From: Diana Hannant [redacted]
Sent: 14 January 2022 12:57
To: David Easton <David.Easton@arun.gov.uk>
Subject: Objection to A/248/21/PL and A/256/21/RES Land north of Water Lane, Angmering

A/248/21/PL and A/256/21/RES

3. Bus and emergency vehicle access from Dappers Lane (iTransport)

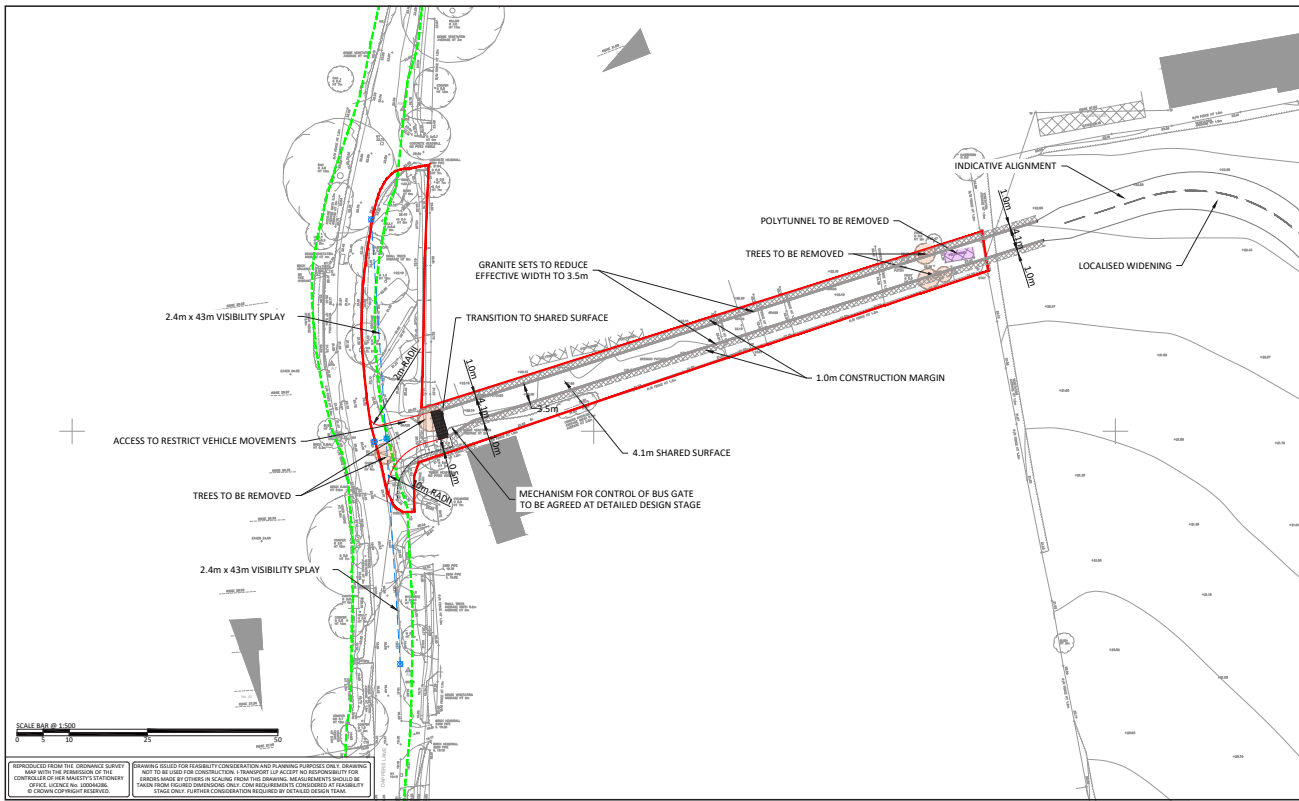
I formally object to the above applications by Rydon Homes to change the original proposal for a mechanised barrier at the bus and pedestrian access route from the site into Dappers Lane, to an ANPR camera.

This will not be effective, it will not be safe, and has no benefit at all to users of the route and in particular to users of Dappers Lane as a whole.

This application shows a new plan for the access route with an ANPR camera and no physical barrier.

However application **A/256/21/RES** p.29 contains a document **20030.33-0100-02-REVB** showing an **"ANPR Camera"** situated at the eastern end to control the access to and refuse the exit from the development in place of the physical control mechanism.

All local residents and regular users of Dappers Lane, especially walkers, cyclists and horse riders, are very much aware that every single day motorists choose to ignore the "bus only" signage at the junction just north of the underpass beneath the A27 and to enter the lane in flagrant breach of traffic regulations to travel southbound, quite secure in the knowledge that they will not be held to account. If drivers become aware that they are physically able to use the access link road between the new Rydon housing estate and Dappers Lane to access or to exit the estate, then it is quite evident that all who have this dismissive attitude to traffic regulations will take advantage and choose to ignore any signage. The presence of an ANPR camera may influence some, but how effective this would be will depend entirely on whether proper and legally enforceable follow up action is taken against all those who are recorded by such a camera.

I urge Arun Planning to value the views and the safety of local residents by turning down the application for an ANPR camera and ensuring that Rydon Homes install a mechanised barrier as originally intended.

It must be refused and the original plan approved in the Outline Planning Permission reinstated.
